Re: Development Review Board Supplemental Submittal
Grace Covenant Church of God - Family Hall Addition Project
1700 57th Street NW, Albuquerque, New Mexico, 87105

On behalf of our Client, The Grace Covenant Church of God, we hereby submit this written description of the plan modifications made to the documents to address the DRB Review Comments dated February 21, 2018.

DESCRIPTION OF DRB SUBMITTAL COMPLIANCE WITH DRB REVIEW COMMENTS

DUMPSTER ENCLOSURE DETAIL

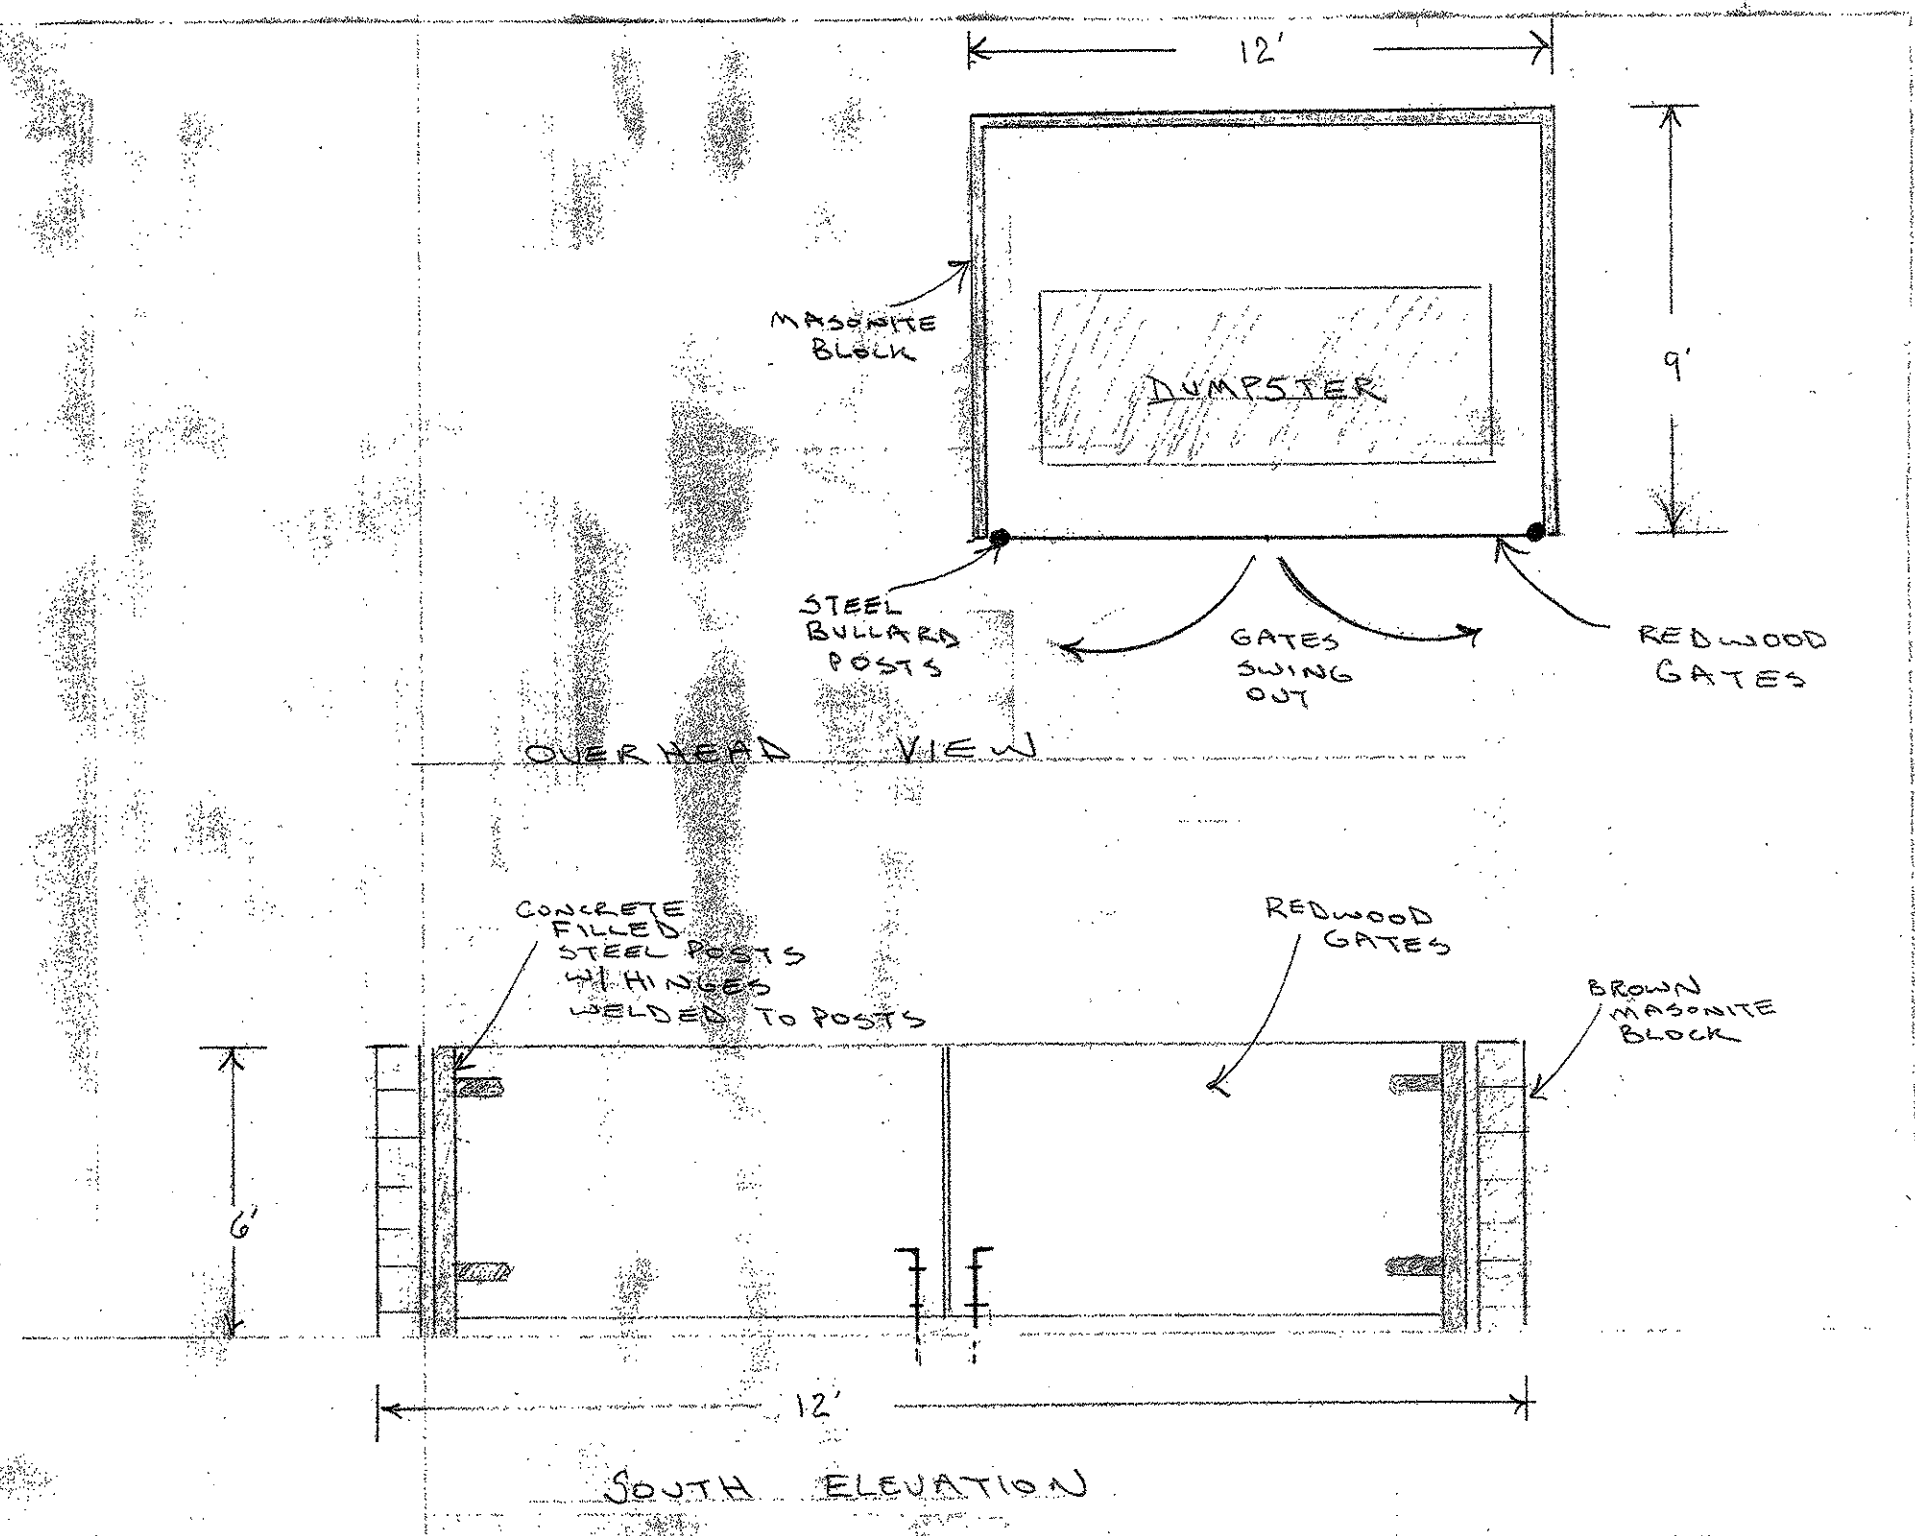
3. *Note that changes have been made to the dumpster site as well as the enclosure [which no longer exists or never did] prior to sign off. This was approved by Solid Waste as an existing condition but it is not in compliance with what EPC approved. Reason for change? No enclosure or screen wall?*

The Solid Waste department approved the current dumpster location and lack of an enclosure based on the existing 80 foot separation of the dumpster location from the public street. At the direction of the Solid Waste department the reference to the enclosure has been crossed out on the Site Development Plan and the actual location of the dumpster indicated on the same. The enclosure detail has been removed from the Elevation and Detail sheet to comport with the elimination of the note on the Site Development Plan.

SIGN DETAIL

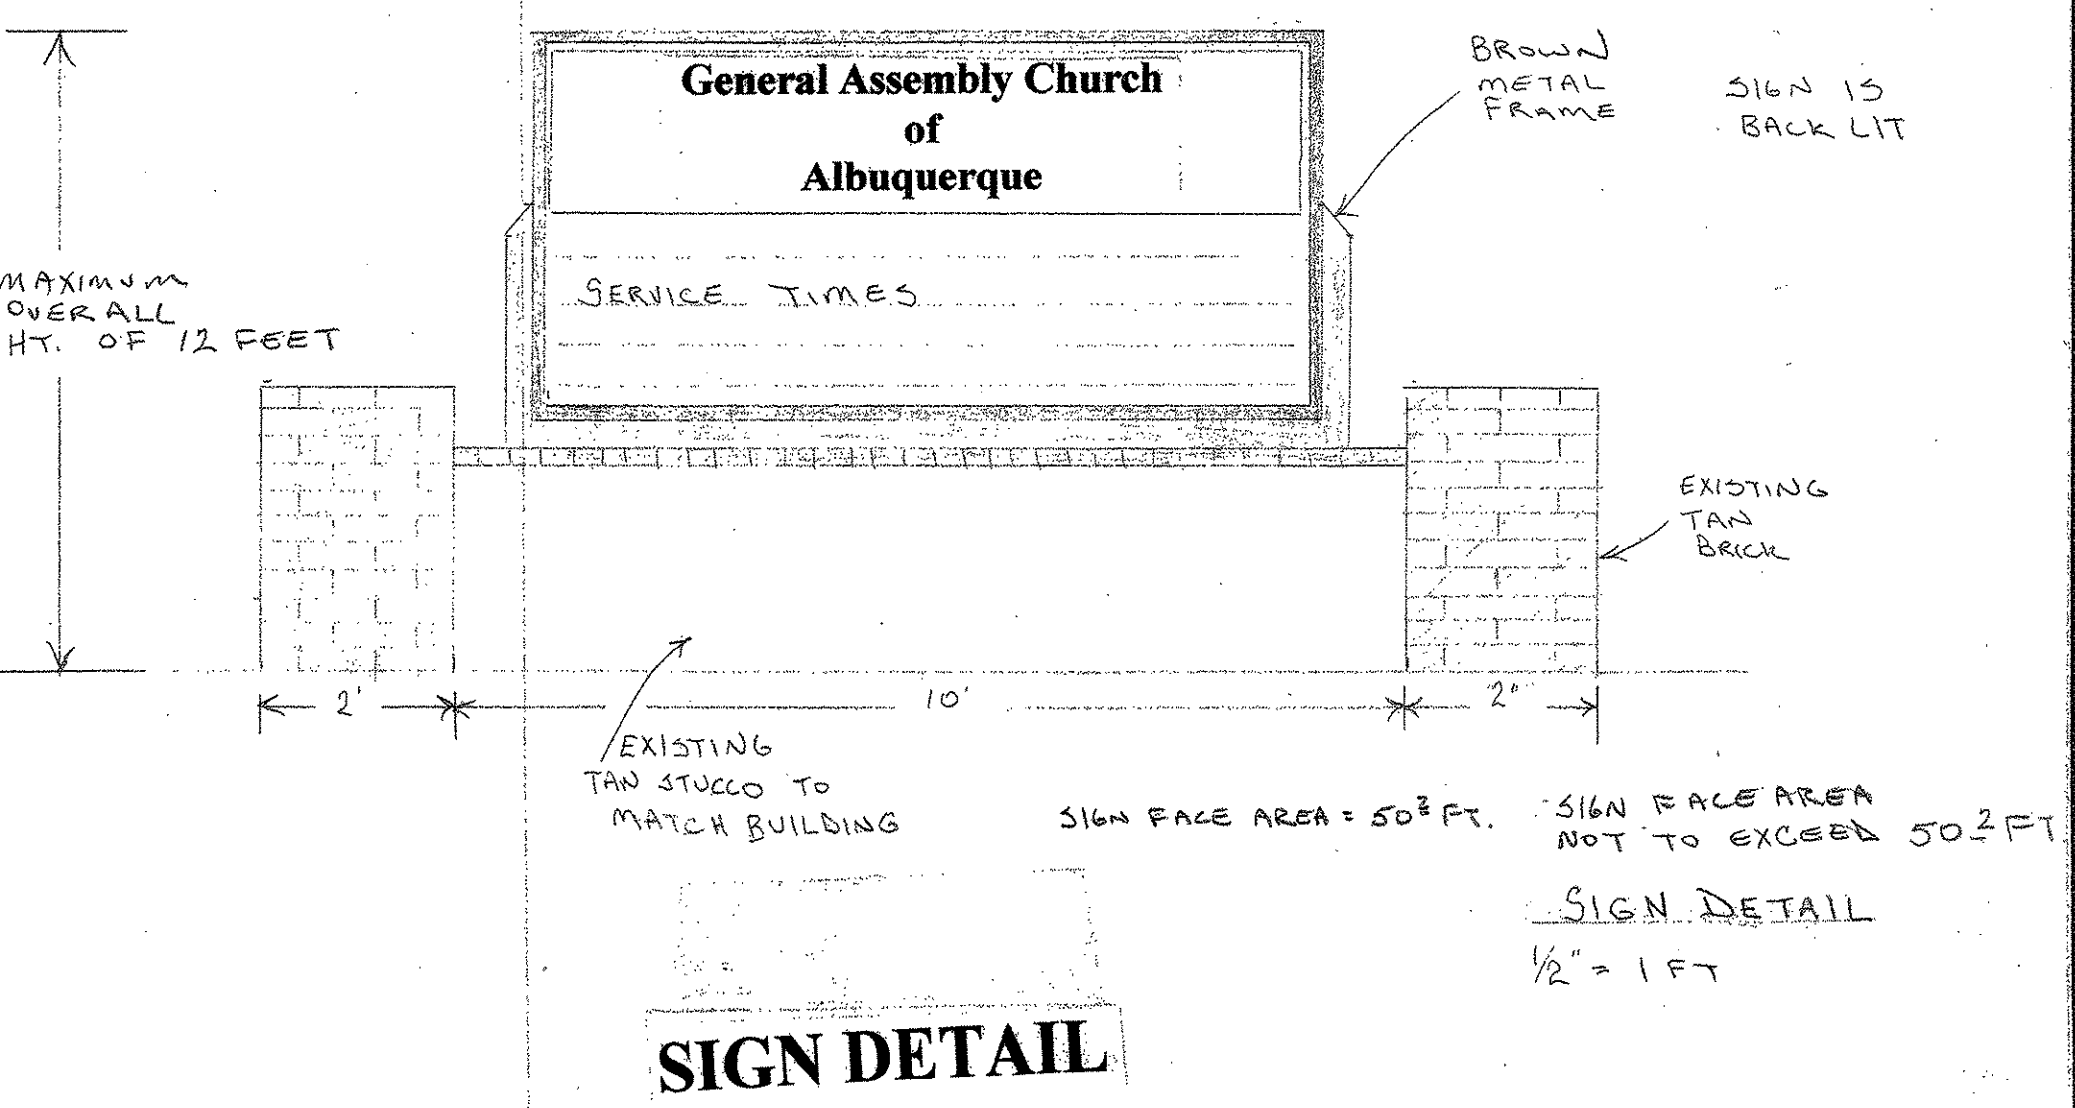
- *5. Sign detail calls for the sign to be 12 feet in height. Must add note that restricts the height, including the base, cannot exceed 9 feet per the CCP. Note the existing sign looks higher than 9 feet. Again, if out of compliance a NOV will be issued.*

The existing sign is under the 9' height requirement. The existing note regarding overall sign height as 12 feet has been amended to indicate that the maximum sign height will be 9 feet including the sign base.
